Your Ref: OWPC3187
Our Ref: R/151/14/HH 30-06-2014
Please ask for:
Mr D Sullivan

23rd July 2014

Retrospective application for dormer and front elevation weatherboard clad.
21 Hawke Close Rustington

Proposed Side Elevation. Scale 1:100

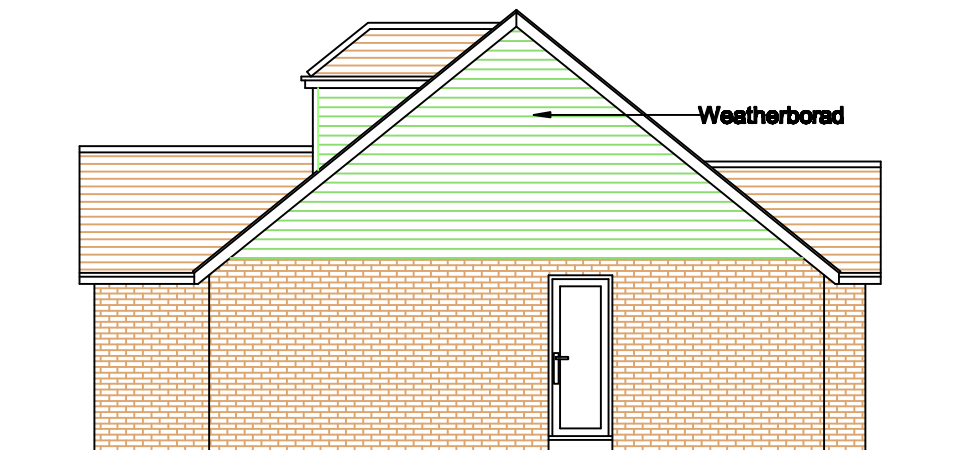
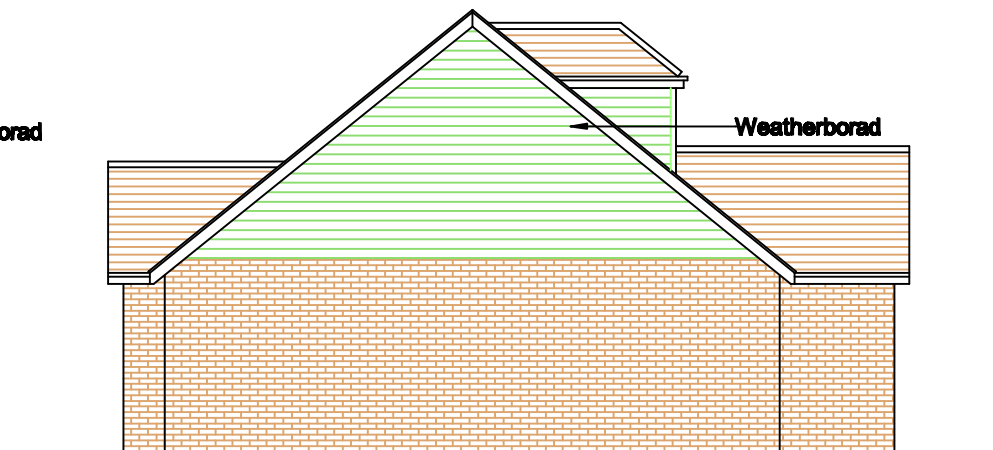
You might care to compare the proposed west facing elevation as shown on the plans with the actual elevation as it is now. The plans show one large window over the stairway and three smaller windows over the bedrooms. The building as it is now has all four windows the larger size, quite clearly not in accordance with the plans submitted.
